Bramford – Twinstead:

Deadline 2 Response

Braintree District Council (20041141) &

Essex County Council (20041299)

234000  
235000  
236000  
237000  
238000  
239000  
240000  
241000  
242000

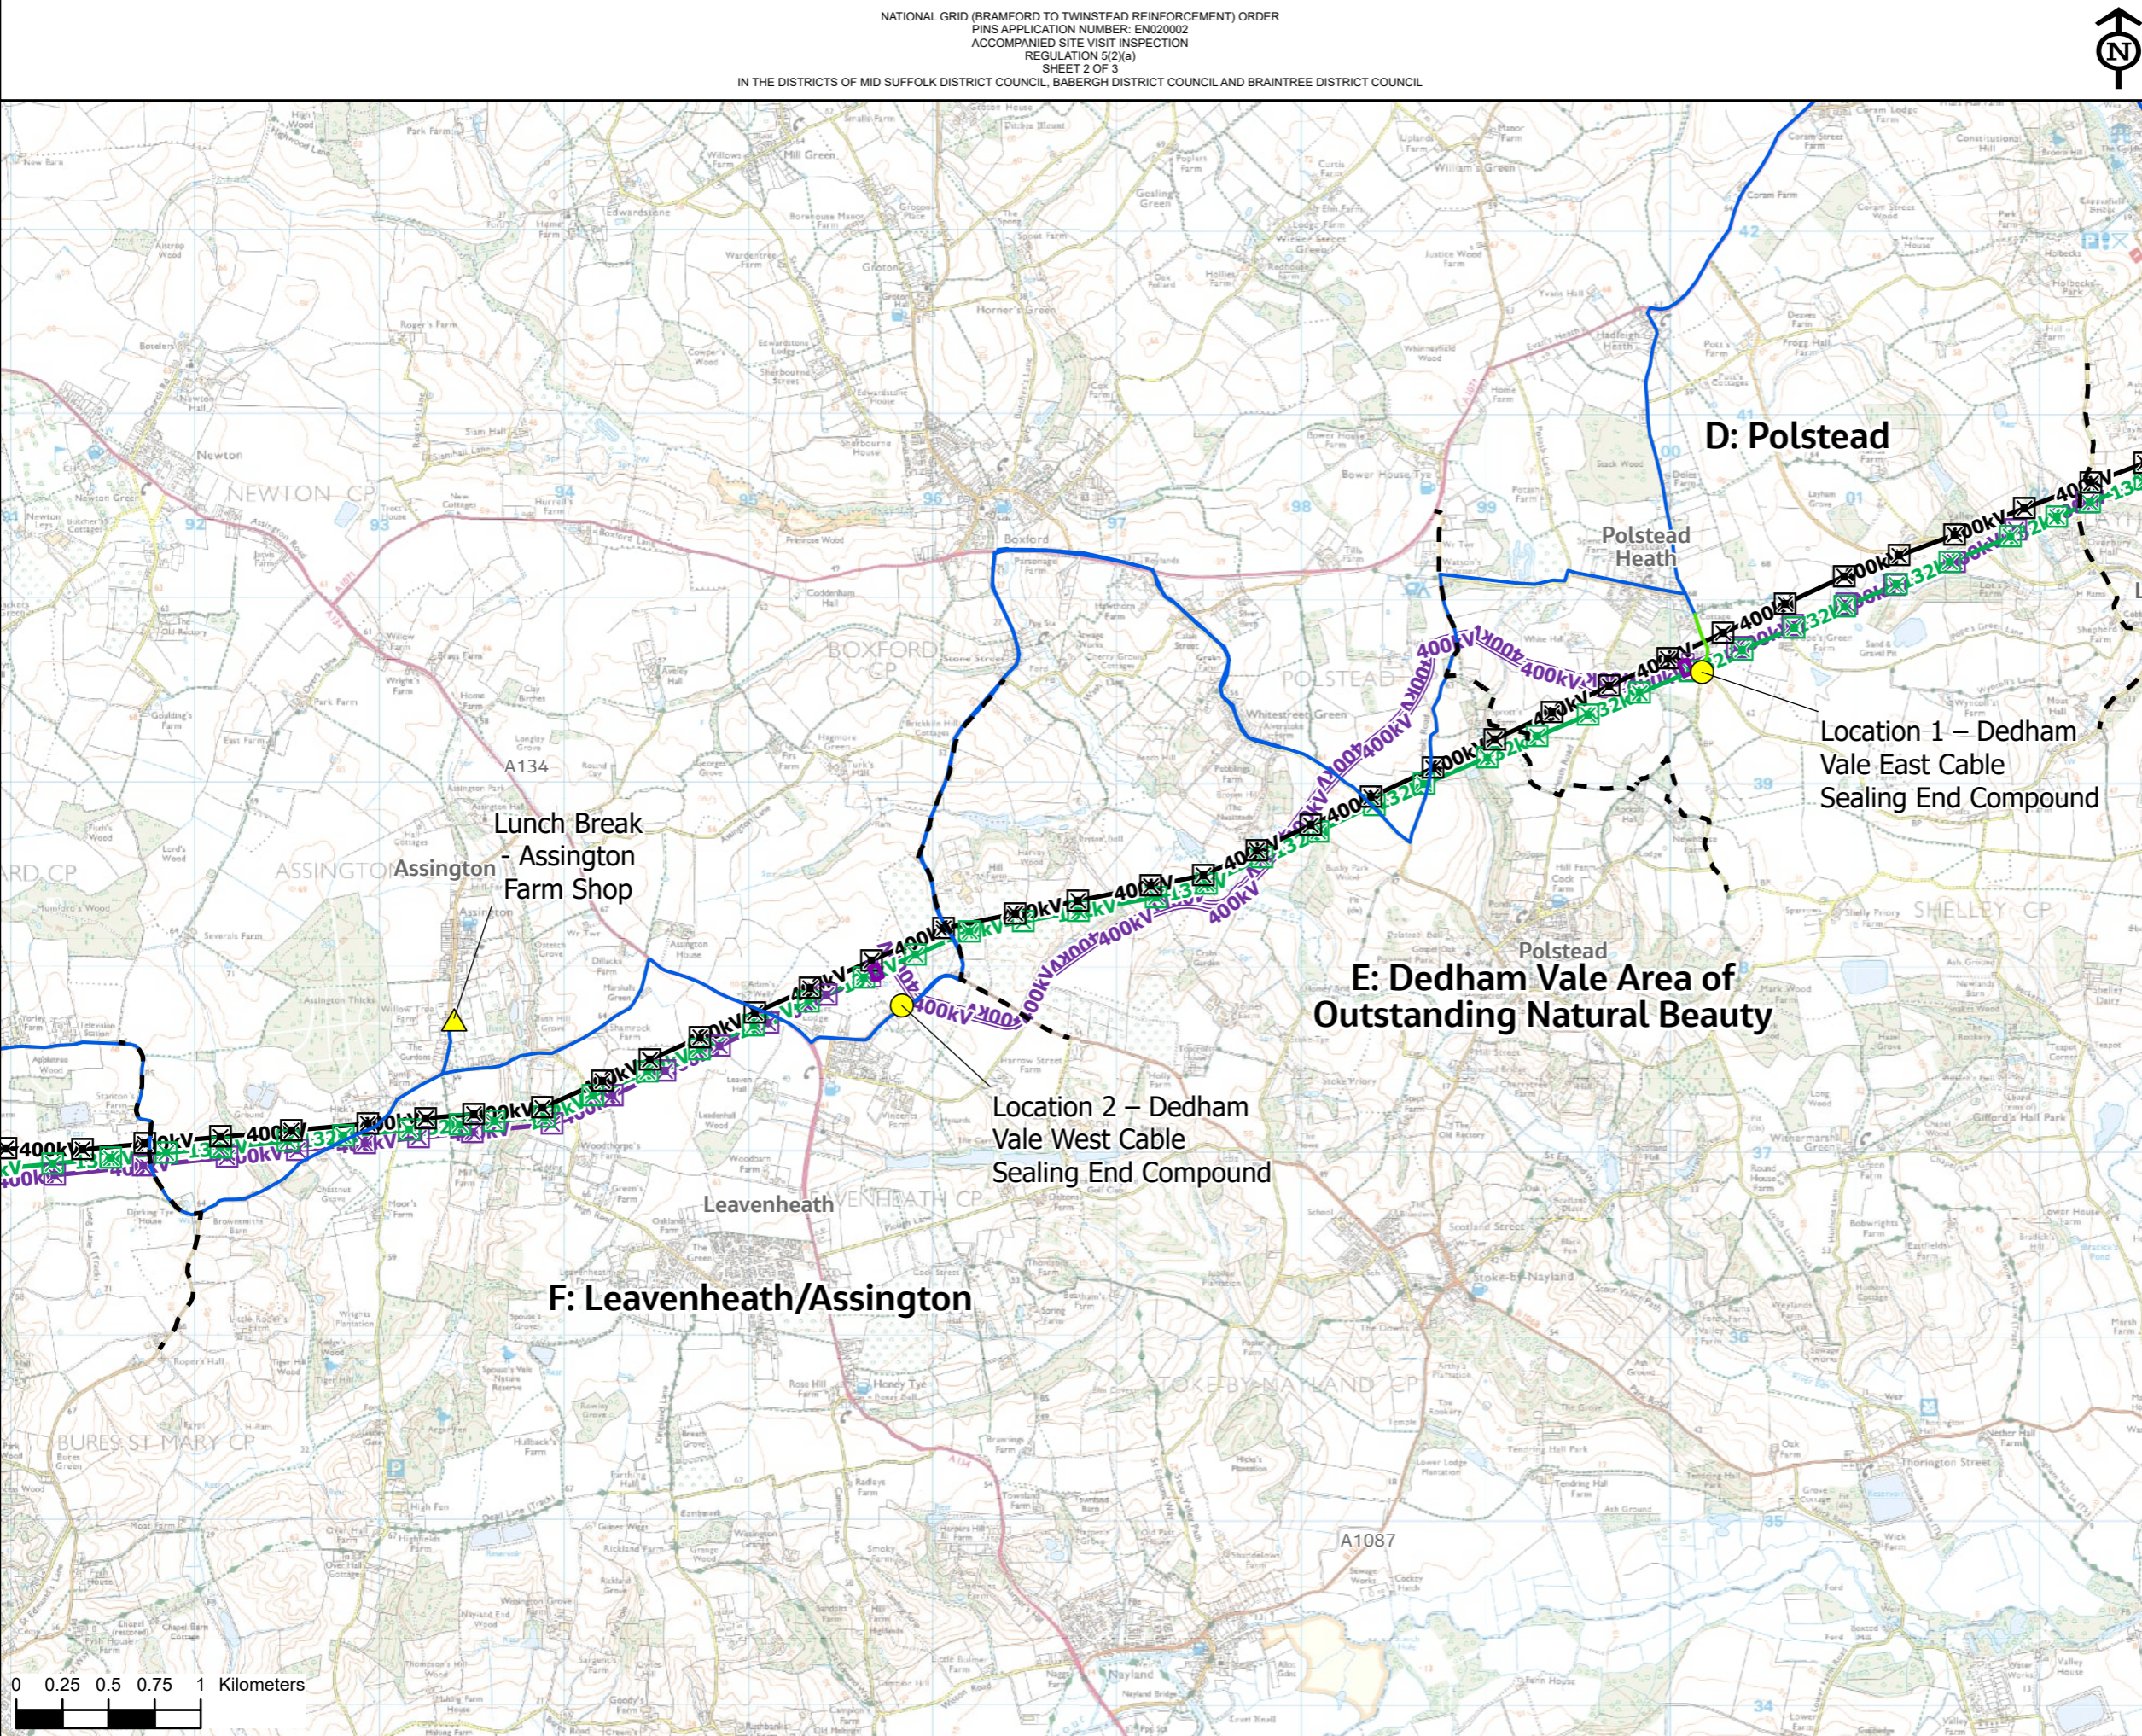
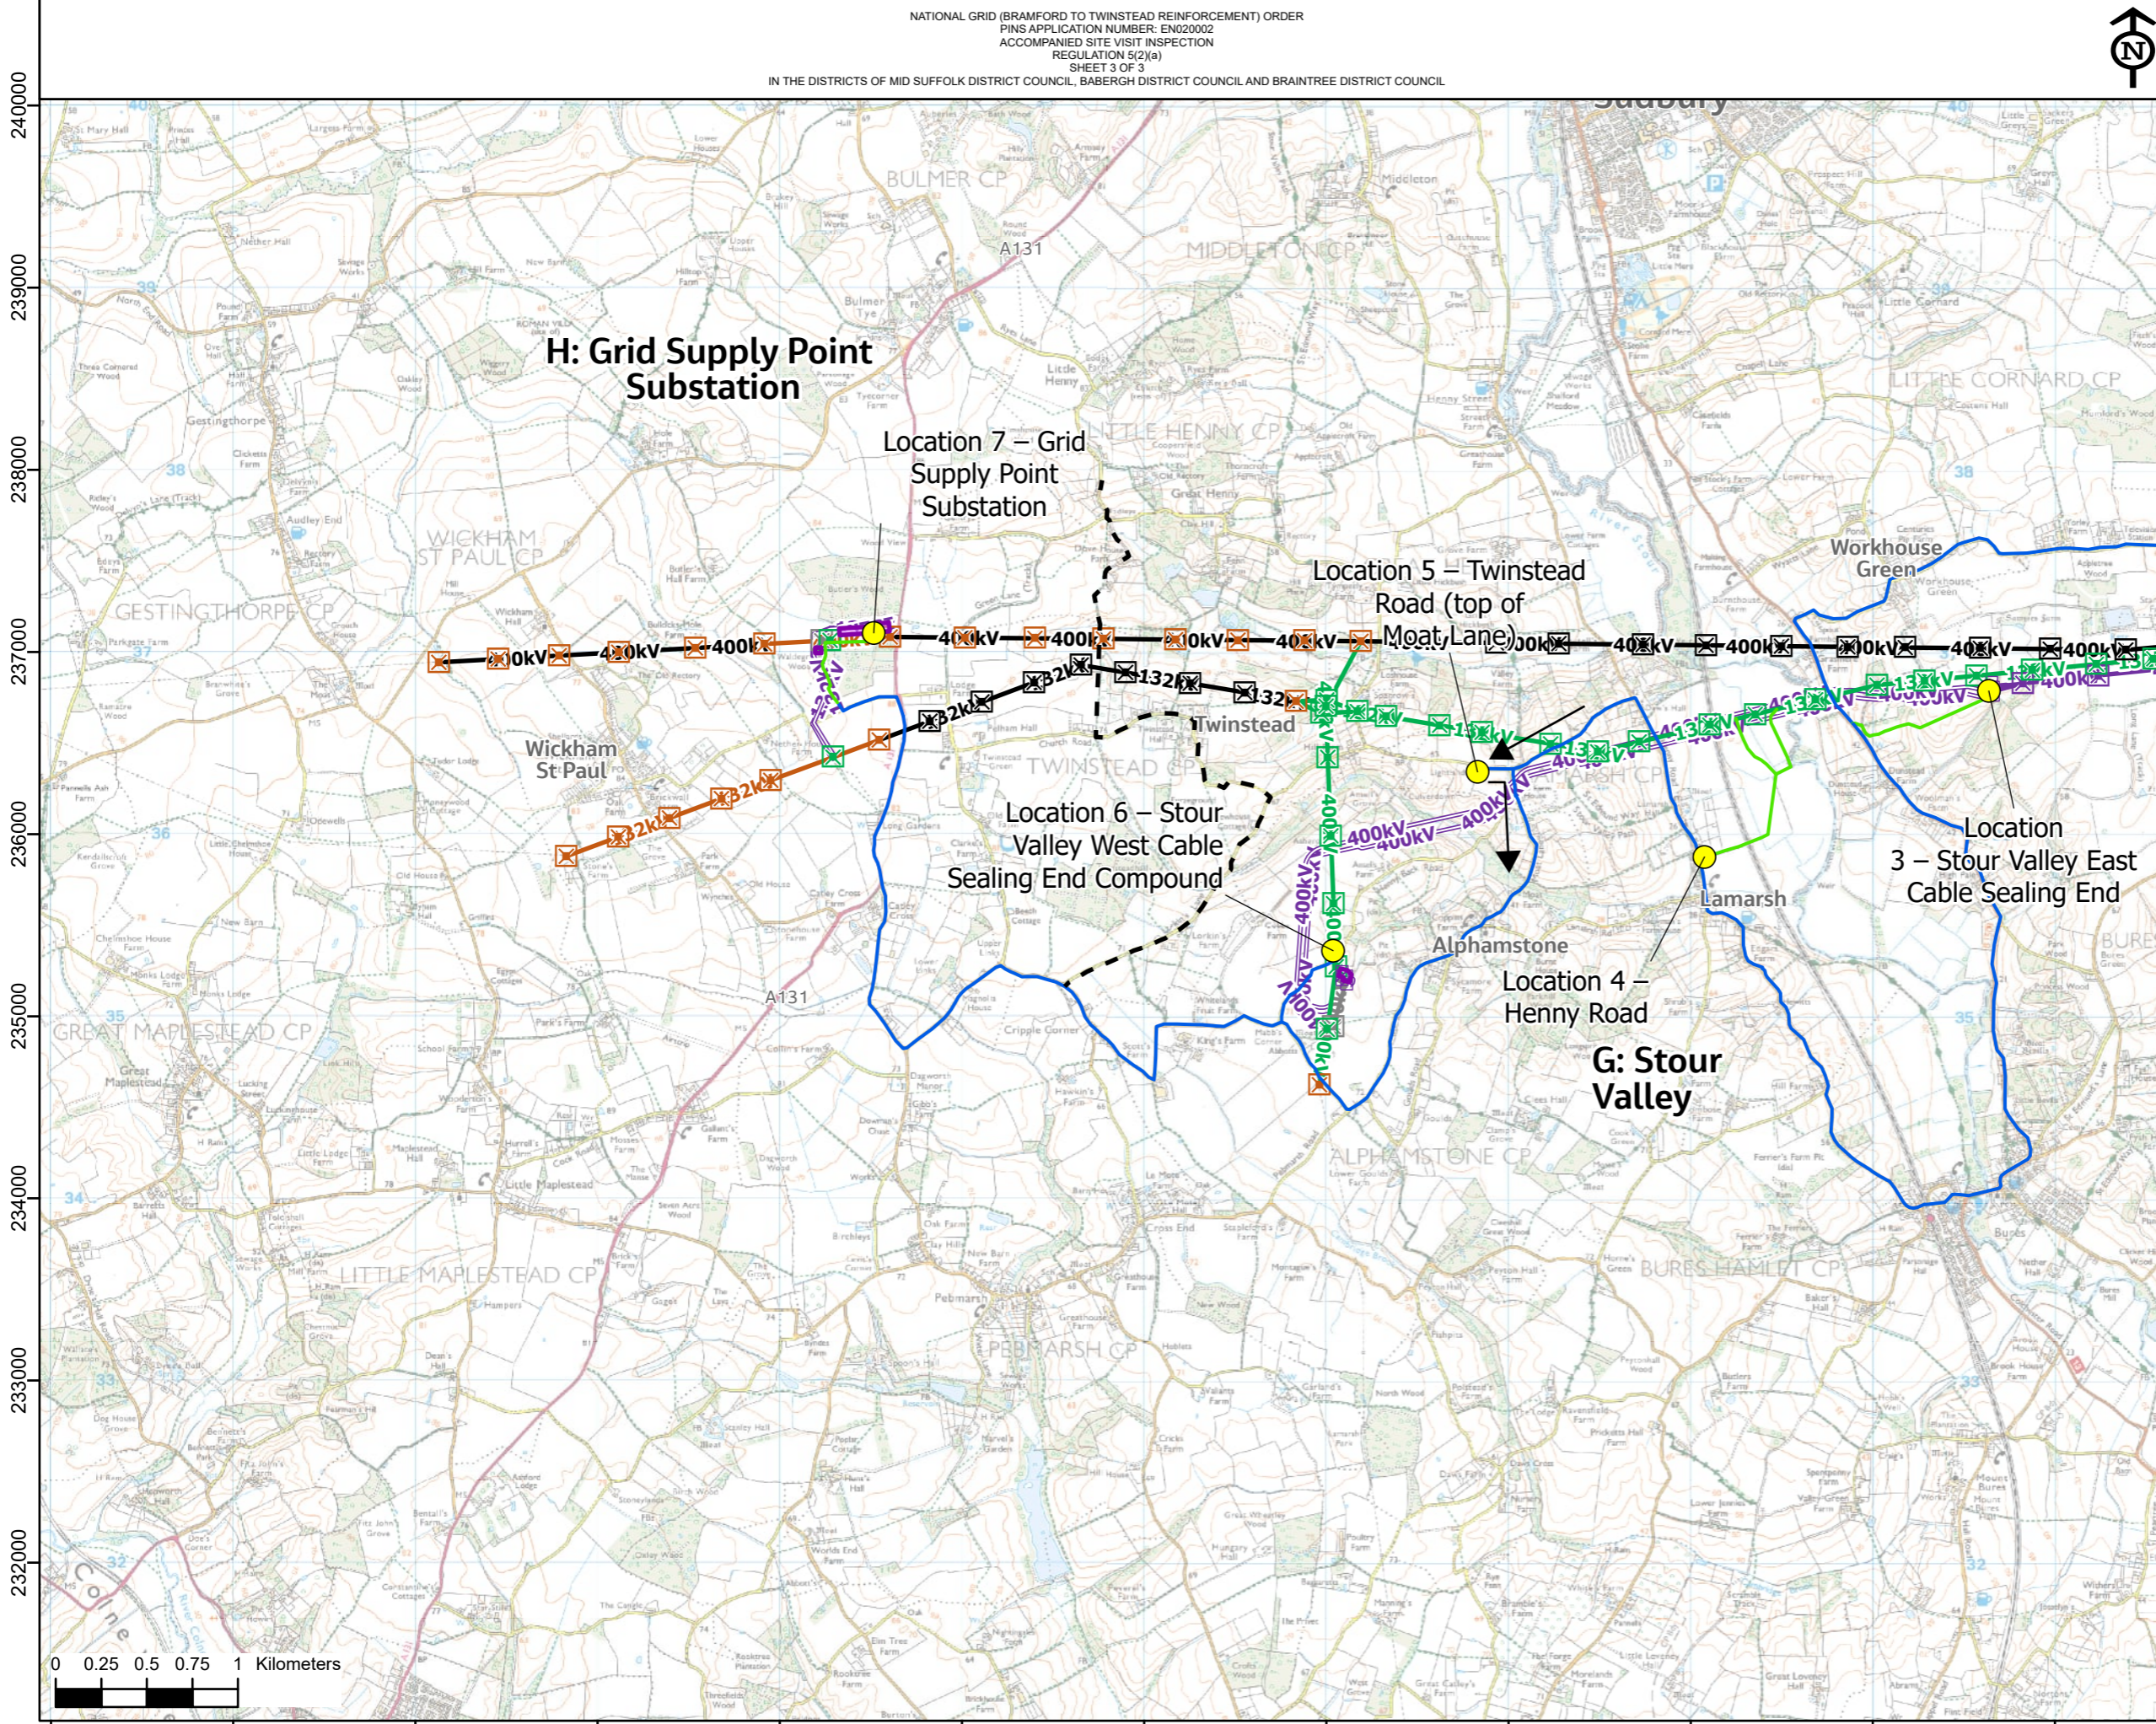
- 3.1.2 The Councils note that Essex is at the end of the route; now that nights are drawing in, it may leave insufficient time to see all of the site in daylight. As such, the Councils propose the ASI is split with those in Essex taking place the following day.

- 3.1.3 The Councils also note that the Draft Itinerary proposed by the Applicant has excluded most Public Rights of Way as locations due to these being publicly accessible and therefore deemed suitable for further unaccompanied site visits. If the proposed itinerary is followed as currently suggested, the Councils urge ExA to visit all the LVIA assessment viewpoints on the PRow network unaccompanied, as a minimum, in order to fully understand the potential long-term visual effects on recreational and other rural receptors and on the local landscape character.

- 3.2.1 There is no location point to view the proposed haul route from the A131 to the Stour Valley West Cable Sealing End Compound; Location 12 is the closest and that would not give an adequate view of the haul route location. The Councils therefore request that an additional Location Point is added to the itinerary to cover the proposed haul route near the entrance from the A131 as this would not be fully visible from any public right of way.
- 3.2.2 The Council's also ask that the ExA consider whether an additional location should be included to view the existing 132kV line which is to be retained

between the Twinstead Tee and the proposed GSP Substation. The purpose of this would be for the ExA to come to their own view about the landscape benefits of the 132kV line removal, as set out in The Council's Local Impact Reports, and which would be made redundant as a result of the proposals, and which the Council's see as being necessary.
